## AONB Partnership ExA Questions pt 1

## AONB Partnership ExA Questions pt 4

# APPENDIX 1 Alison Farmer Report on Preliminary Environment Information; Beach Landing Facility

## Sizewell C Beach Landing Facility Comments on Preliminary Environmental Information (PEI) Chapter 3 – Freight Management Strategy

**Figure 1.2: The location of ~~enhanced permanent and temporary~~ the Beach Landing Facilities (BLFs) Facility (BLF) and Marine Bulk Import Facility (MBIF) showing the pile locations relative to local bathymetry.**

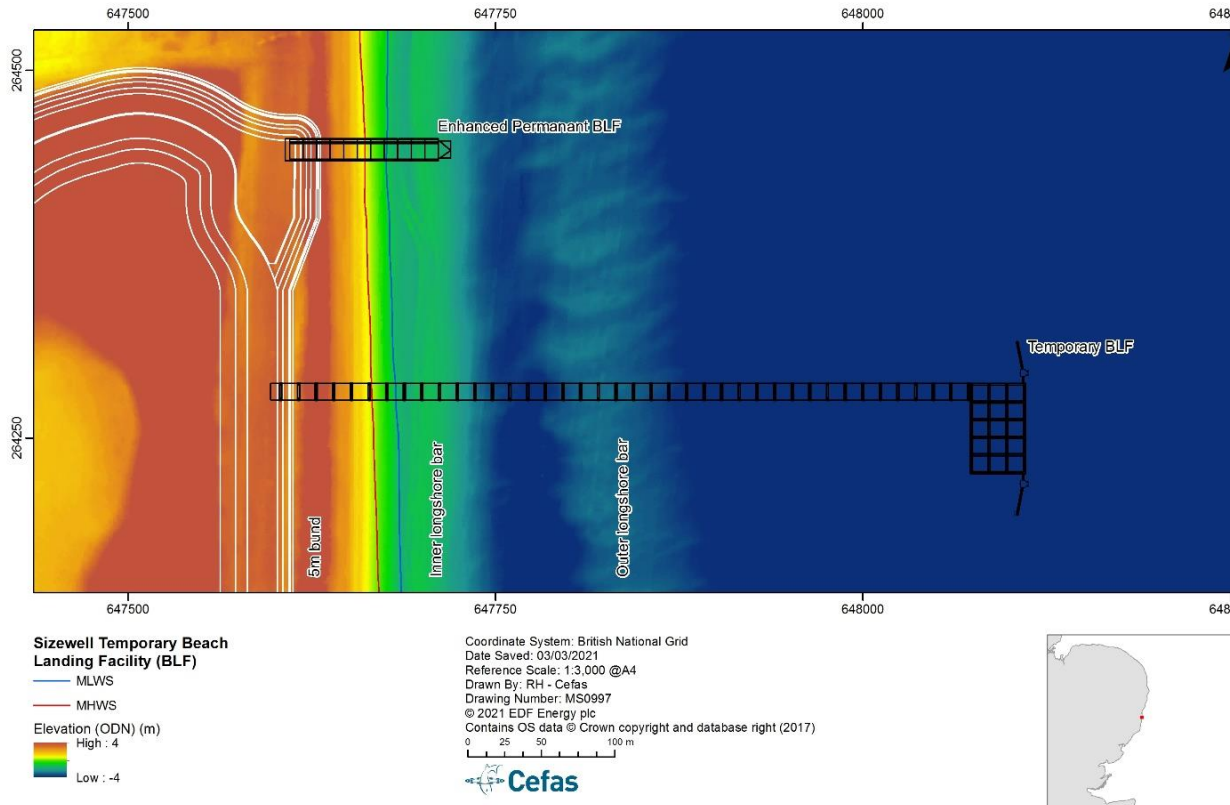
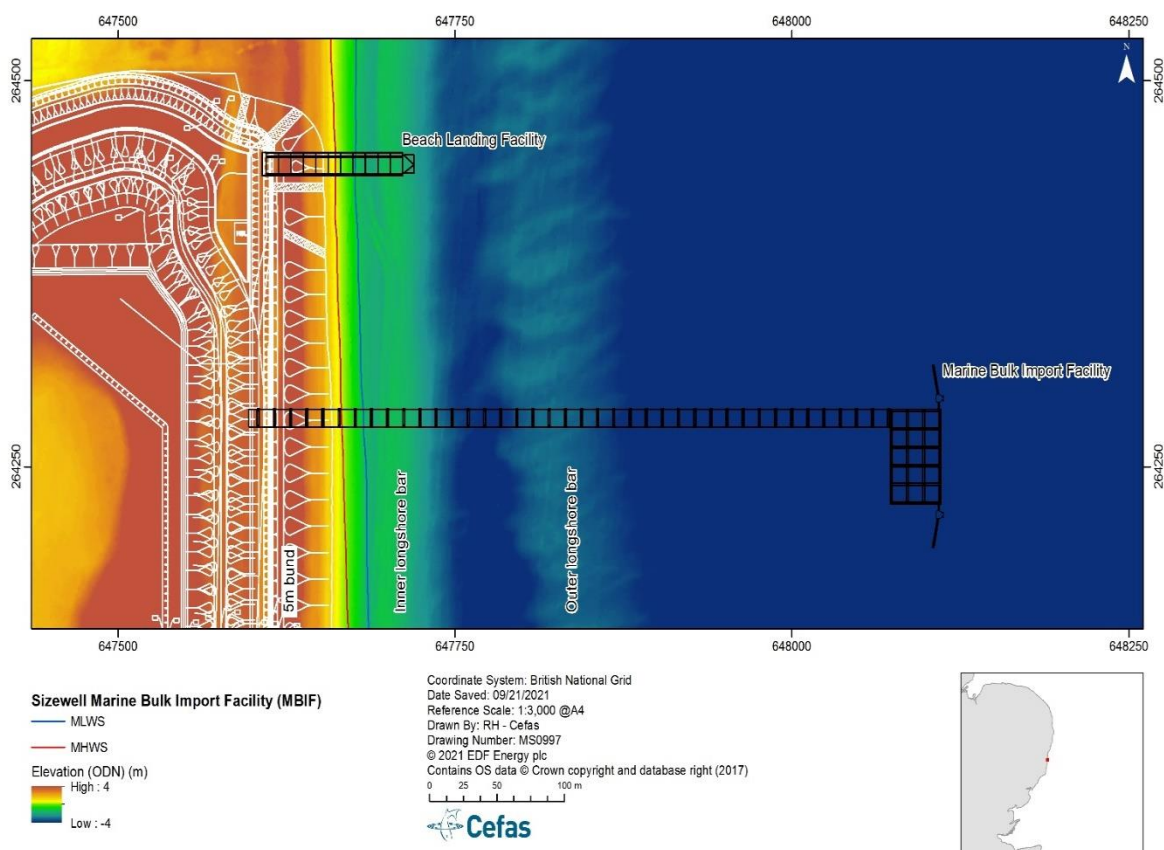
2.2.3 In simple terms the proposed changes will result in increased length of pier, introduction of grillage and increase usage. However, the level of information provided in the PEI is limited and no visual material is provided to show the proposed changes. Figure 2.10 of the ES shows the PBLF but when it is not in use. Visualisation of it in use (as a worst case scenario) and in relation to the proposed enhancement would be beneficial.

- 2.3.1 Were landscape and visual effects have already been identified as significant adverse within the ES, the proposed changes to the PBLF are unlikely to make a difference to overall judgements. However, this is not to say that the proposed changes will have no effect. Clearly increased activity and use of the PBLF will also give rise to increase vehicular movements and noise, as well as increased activity in offshore waters. As a result there will be further negative effects on the AONB's defined qualities of landscape quality, scenic quality and tranquillity

- 2.3.2 Where landscape and visual effects are judged to be moderate adverse the proposed changes to the PBLF may give rise to an increase level of effect particularly in views along the coast where the BLF is seen to project further out to sea, and more AILs are being delivered to site.

- 2.3.3 It is noted in Table 3.6 page 48 that no further assessment is required for the enhancement to the permanent BLF. However, given that the effects will occur within a nationally designated landscape it is considered important that they are nevertheless set out in detail and evidence provided as to where effects have been mitigated as far as possible. The proposed alteration to the PBLF is likely to give rise to affects in the AONB such as:

- 2.4.1 To be clear about the detailed effects and to ensure adequate mitigation in relation to the AONB it would be helpful to have the following additional information:
- detailed drawings of enhanced PBLF structure/layout
  - Information on method of construction (especially grilling and extent to which any new structures will be visible above the waterlevel)
  - additional visualisation from VP 31 looking along the coast and out to sea to show the effect of PBLF and proposed changes.
- 2.4.2 Additional clarification is also required in relation to the following:
- Any increased length of time required to construct the enhanced PBLF

3.1.2 In all options the TBLF will be longer than the PBLF. It is also noted that the TBLF is likely to be narrower and the structural components (such as piling) would also be reduced in size accordingly (para 3.3.33). It is not clear why in Option 1 a 120m pier can only accommodate 70 deliveries over a campaign where as the PBLF at 70m or even 100m long can accommodate 100 barges per campaign.

3.2.1 All four options are likely to give rise to landscape and visual effects and impact on the special qualities of the AONB. In simple terms the longer and more substantial the pier the more visible it is likely to be for greater distances along the coast. In addition the more activity and deliveries by barge the greater the effects on landscape character and special qualities of the AONB. All four options will result in physical landscape effects across the beach in the vicinity of the main construction site. These effects are considered in more detail below:

- The consideration of the four TBLF will require a comparison of the visual effects of each. Use of ZTVs for each option will help to demonstrate how a longer length of pier will give rise to increased visibility of structures in the offshore environment and thus along the coast. This will also inform how this increased visibility may affect the special qualities of the AONB
- Particular viewpoints which will need review include: 6, 17, 26 and 31.

- Width and height of pier and hopper
- Layout plan showing both Temporary and Permanent Piers, hopper, conveyor, access road, coastal path, sea defence, main construction site and any new temporary storage facilities for aggregate.
